Road Safety Audit Report

Proposed Roundabout along the A325
Holt Pond

Report Title:	Stage 1 Road Safety Audit
Date:	December 2023
Document reference and revision:	RSA-23-140-4
Prepared by:	Fenley Road Safety Limited
On behalf of the Overseeing Organisation:	Hampshire County Council
Design Organisation:	i-Transport
Project Sponsor:	Haskins Garden Centre

The Square, Basing View,  
Basingstoke, Hampshire, RG21 4EB  
www.i-transport.co.uk

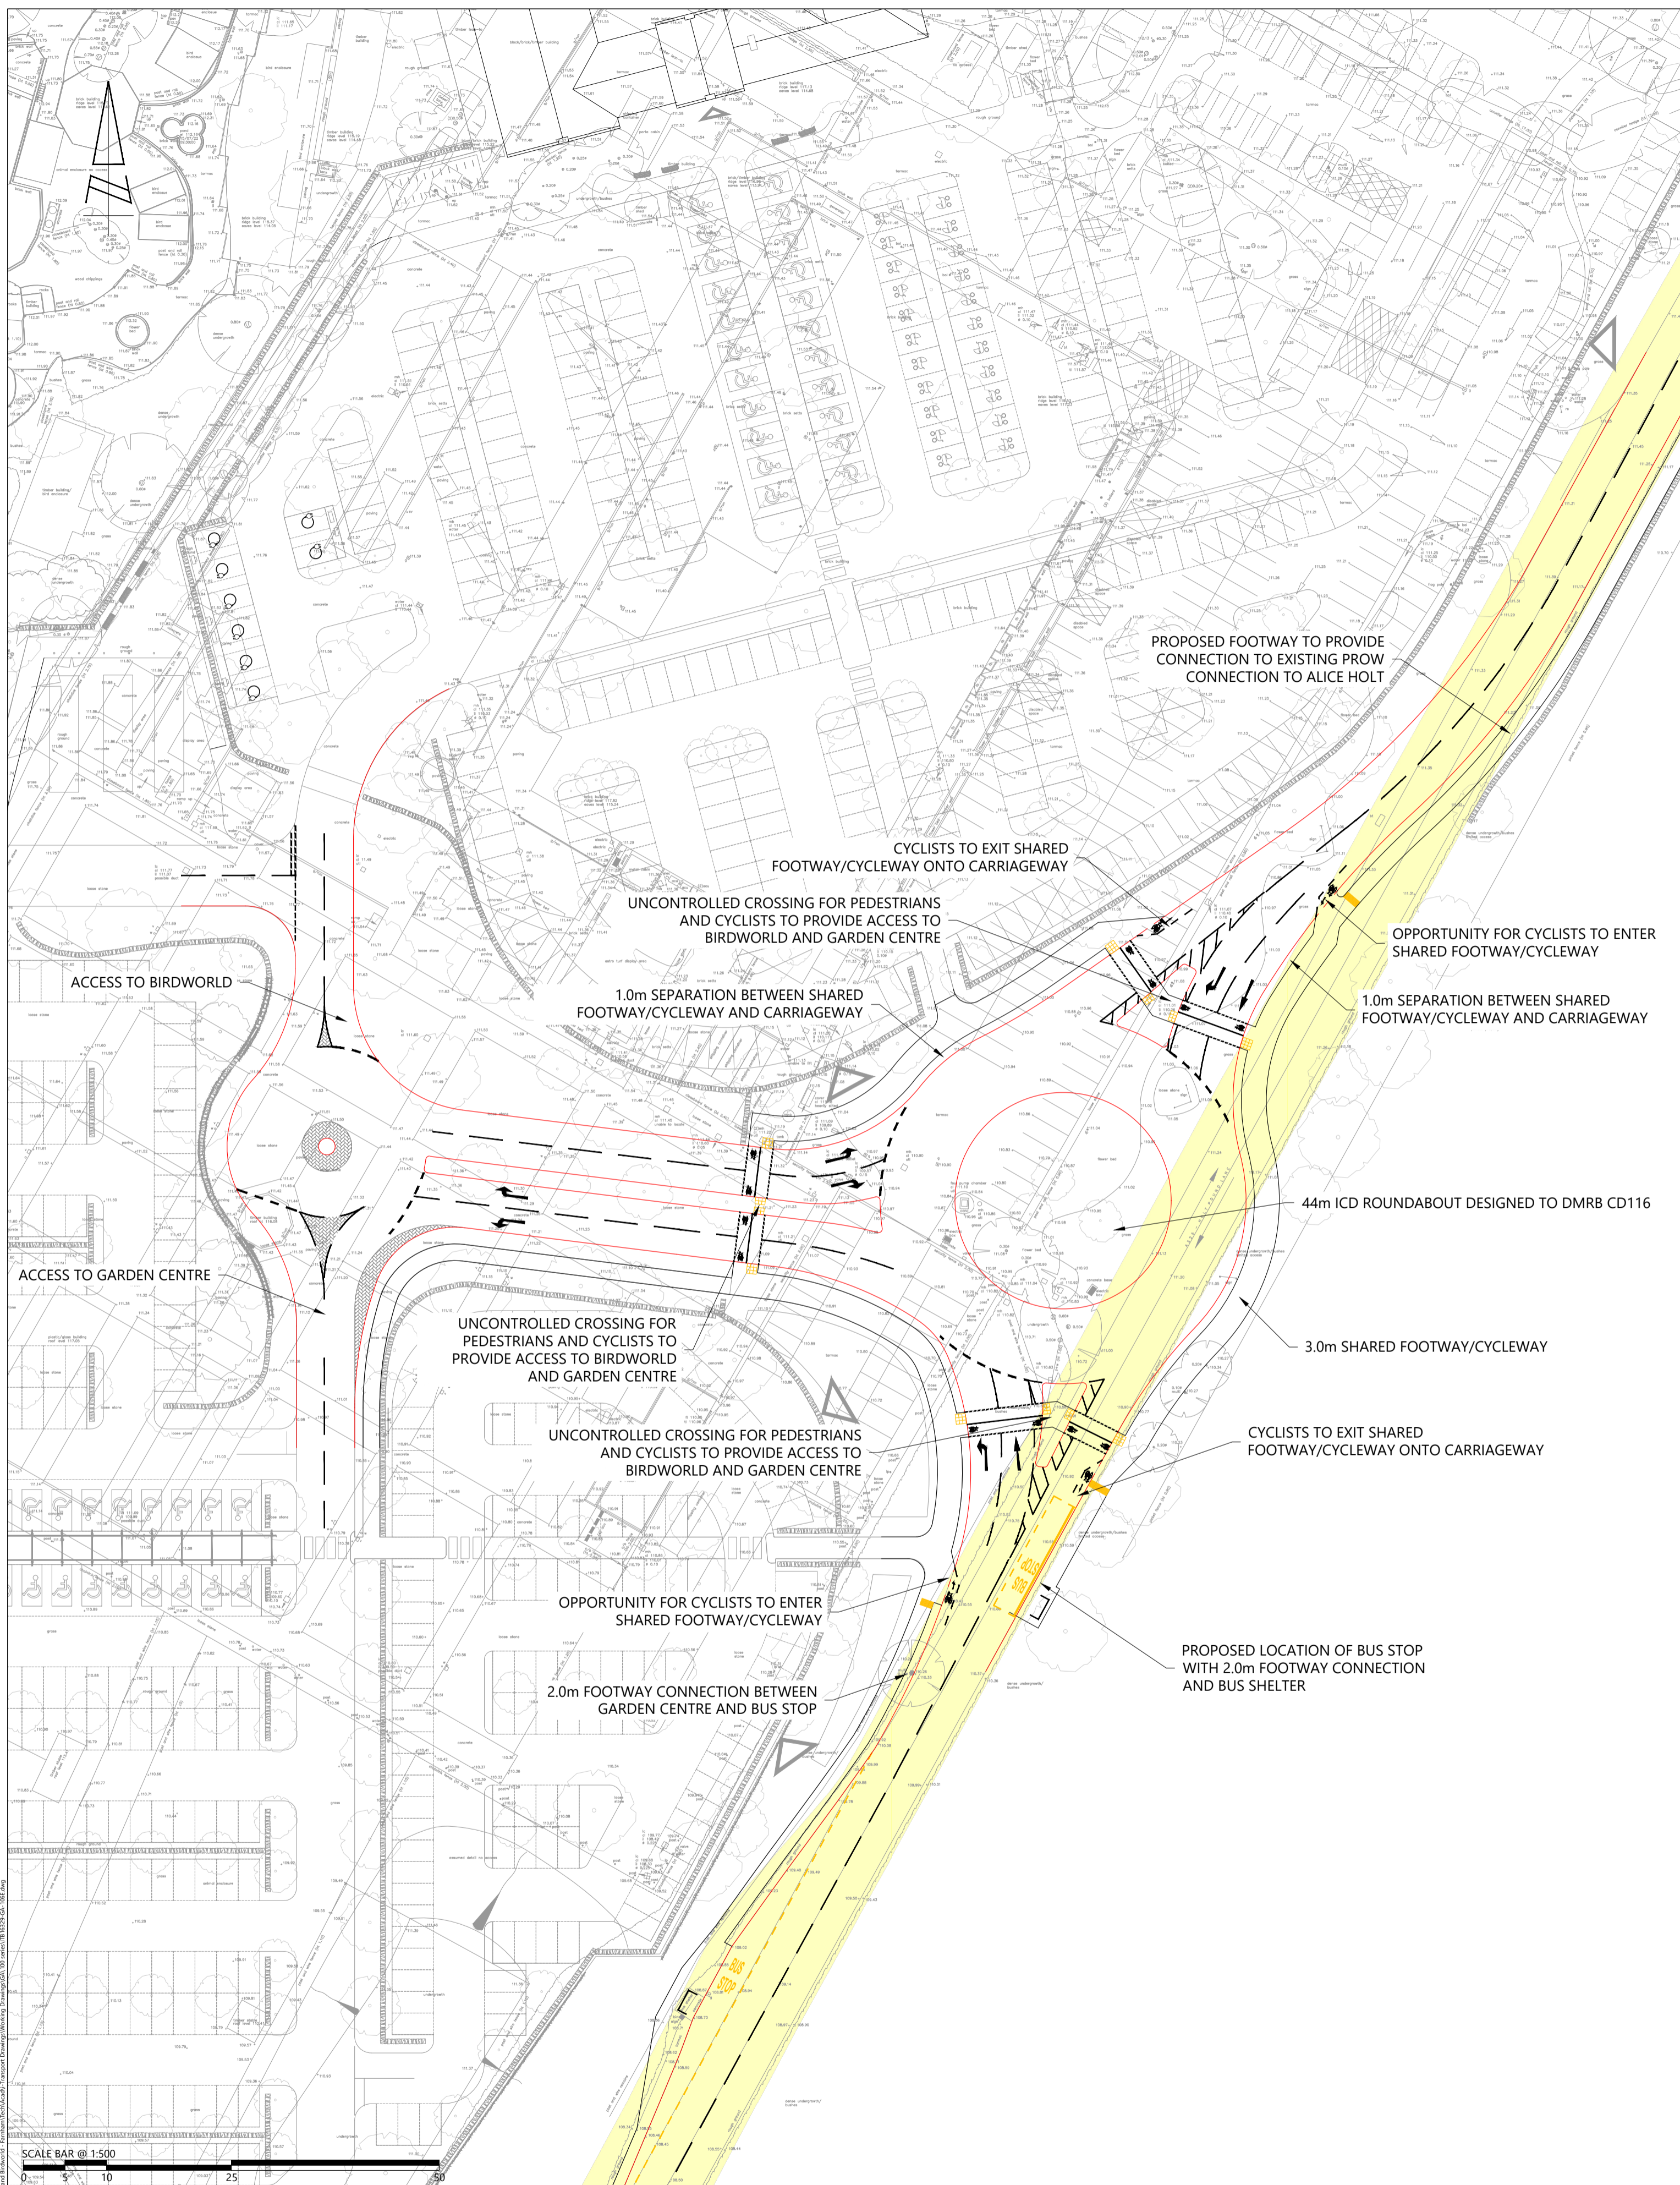
The A325 is straight in alignment, subject to a 50mph speed limit and passes the existing priority junctions associated with the Haskins Garden Centre and Birdworld attraction that are both accommodated within the application site. The proposals include the provision of a three-arm roundabout along the A325 which is to serve a redeveloped Garden Centre and Birdworld. The scheme drawings provided with the Audit Brief identify that a footway is to be accommodated both sides of the development access in proximity of the roundabout. The proposed footway is to extend to bus stops to the south and continue along the eastern side of the carriageway to a public right of way, to the north with uncontrolled crossings provided which benefit from refuges accommodated at the splitter islands on each arm. Whilst the general provision of a footway is

acceptable, the Audit Team has concerns that wind forces generated by large vehicles passing at high-speed, could destabilise a pedestrian leading to a fall and personal injury or vehicle to pedestrian type collisions.

It is recommended that the proposed footway is offset from the carriageway by an appropriate margin.

Agree – The design has been revised to provide a minimum margin of 500mm between the edge of carriageway and footway edge (see Drawing ITB16329-GA-106 revision C).

Confirmation that a margin is to be provided, addresses the road safety concern raised at this stage.

DRAWING No: ITB16329-GA-022 REV: F

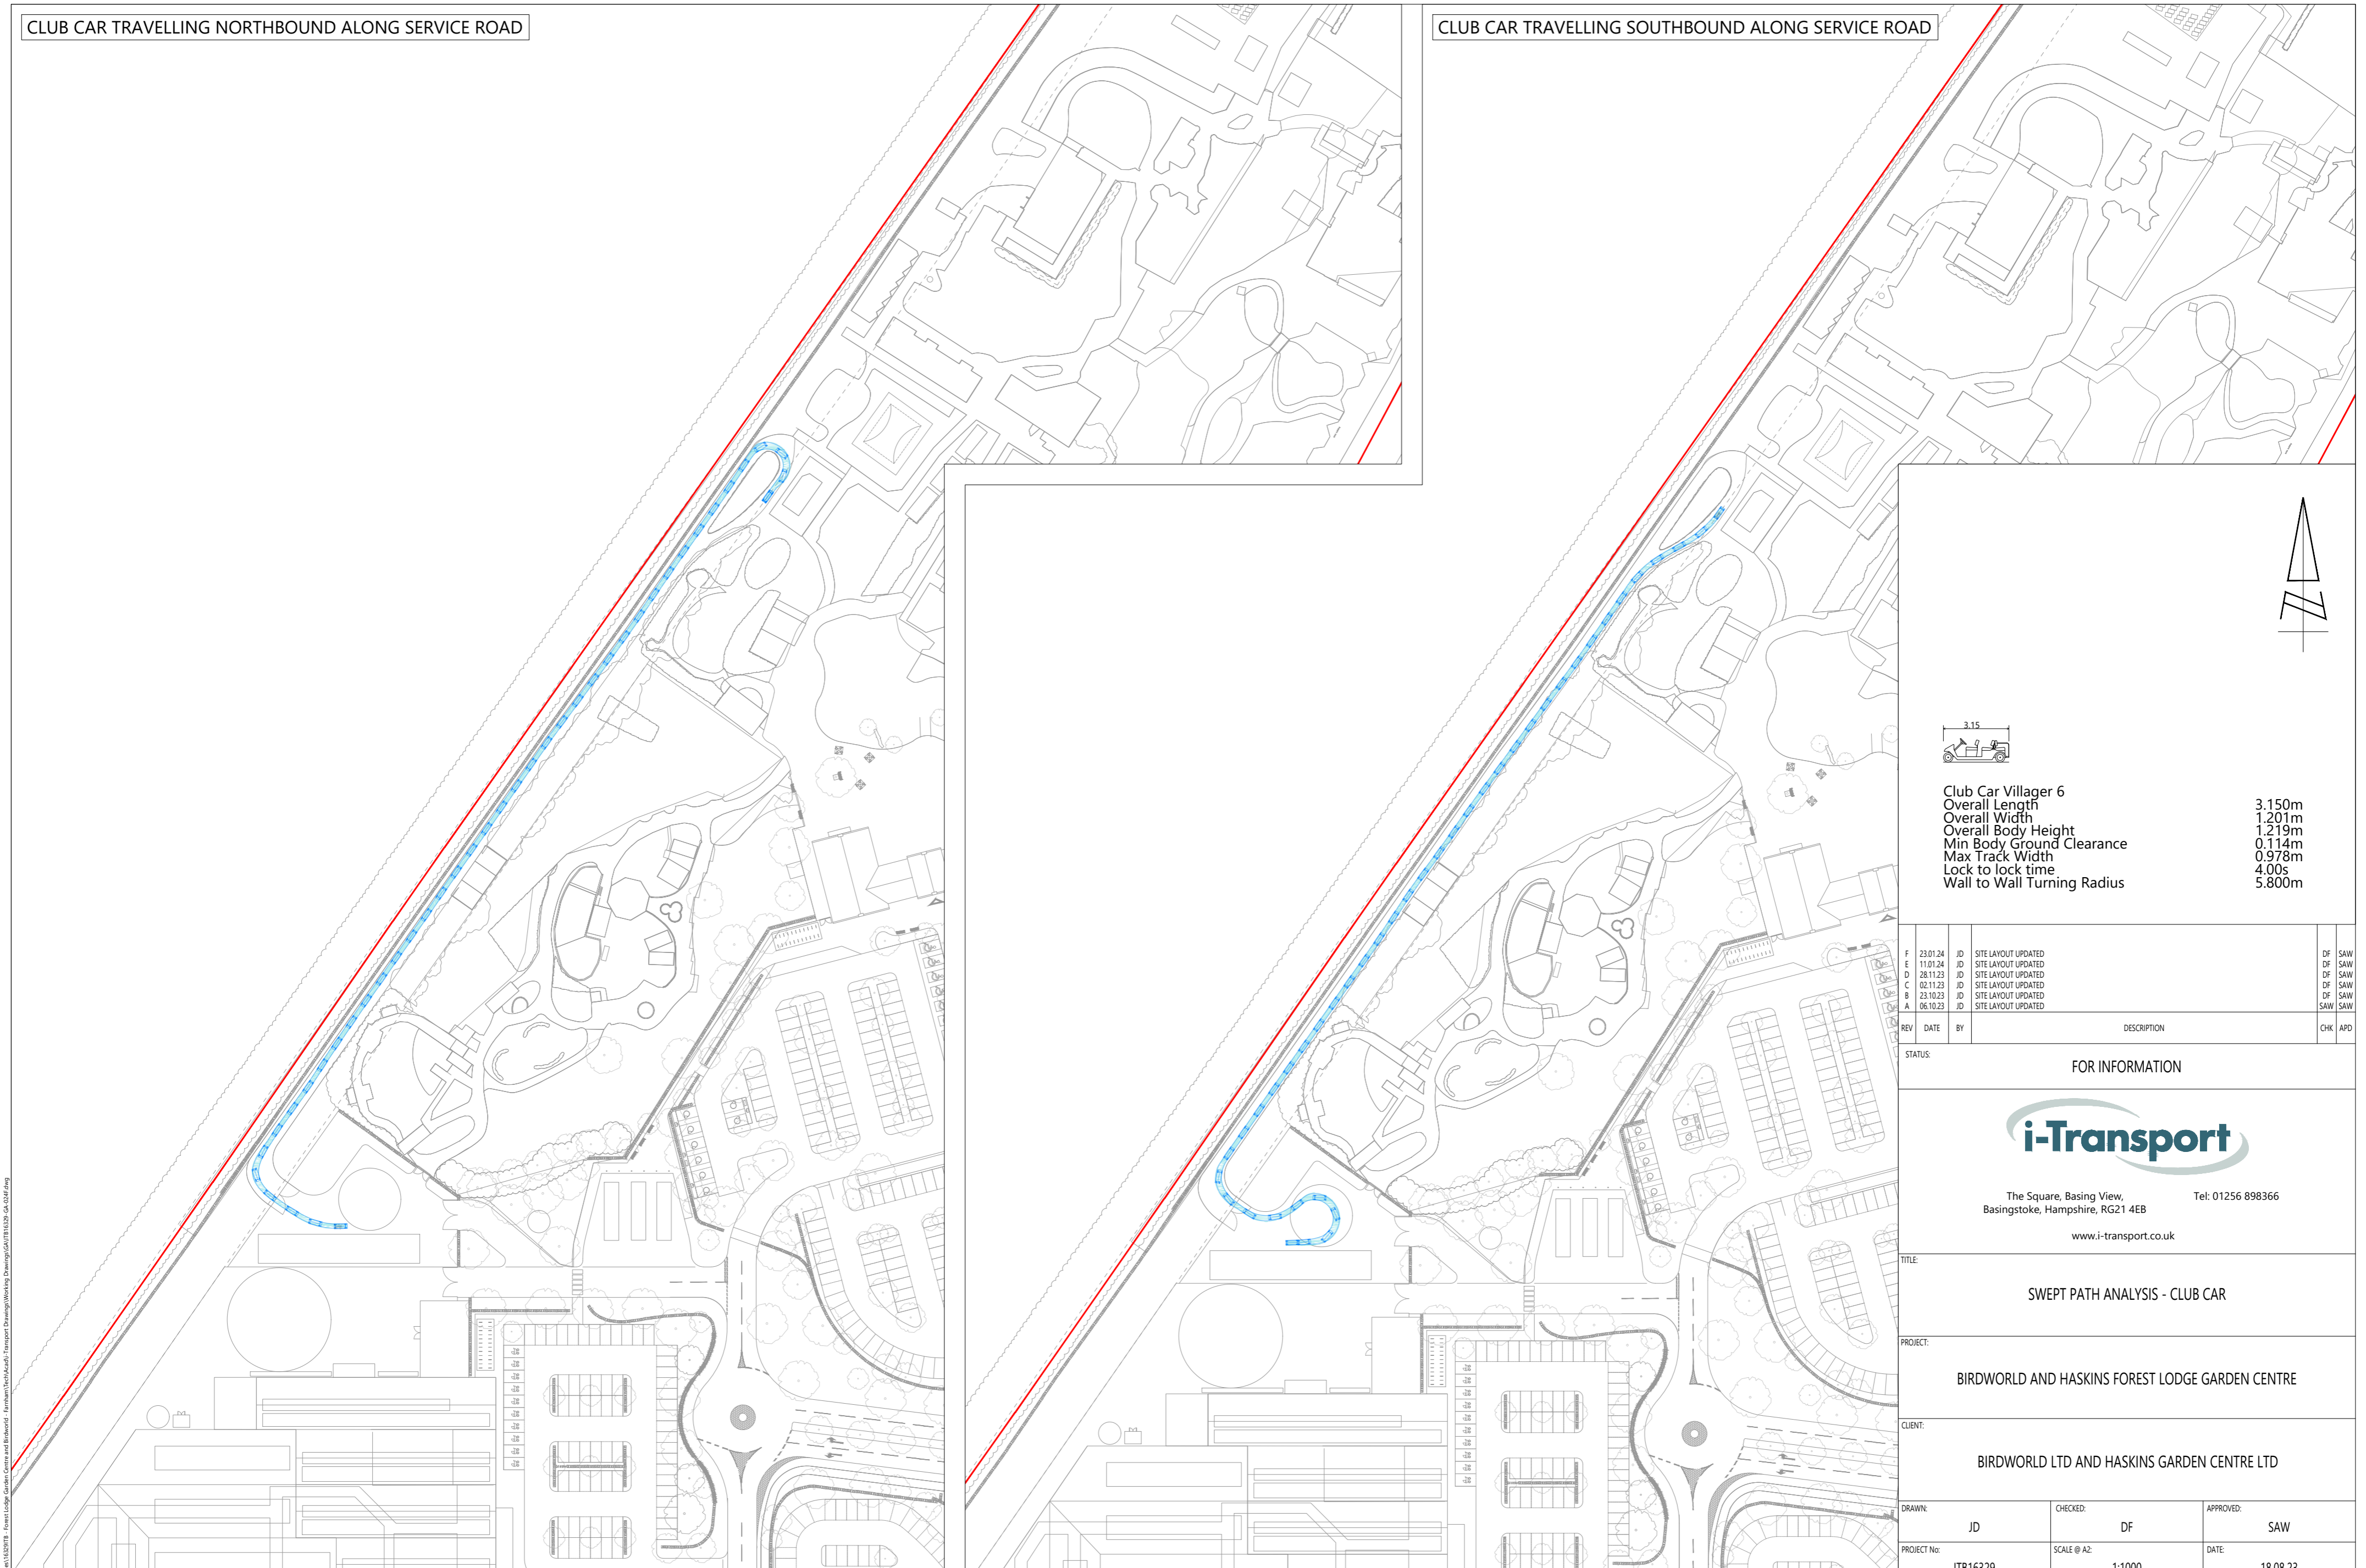
between the A325 and a mini-roundabout serving two separate parking facilities. The scheme drawings illustrate that the proposed garden centre is to be serviced via a simple priority access off the northern arm, however, no swept path analyses have been provided. The Audit Team have concerns that the HGV's will not be able to negotiate the infrastructure which could lead to sideswipe type collisions as well as the vehicles encroaching the footway increasing the risk to pedestrians.

It is recommended that the infrastructure is adequate for the expected vehicles.

Agreed – Vehicle swept path analysis of typical service delivery vehicles likely to be associated with the development has been undertaken and shown on Drawing No. ITB16329-GA-021 and ITB16329-GA-022. This demonstrates that vehicles can enter, turn and exit the internal arrangement including the service areas. Whilst it is noted that some movements result in the overrun of the opposite lane, these movements will be infrequent, in a low traffic speed environment and with good intervisibility in all directions.

Confirmation that the infrastructure is adequate, addresses the road safety concern raised at this stage.
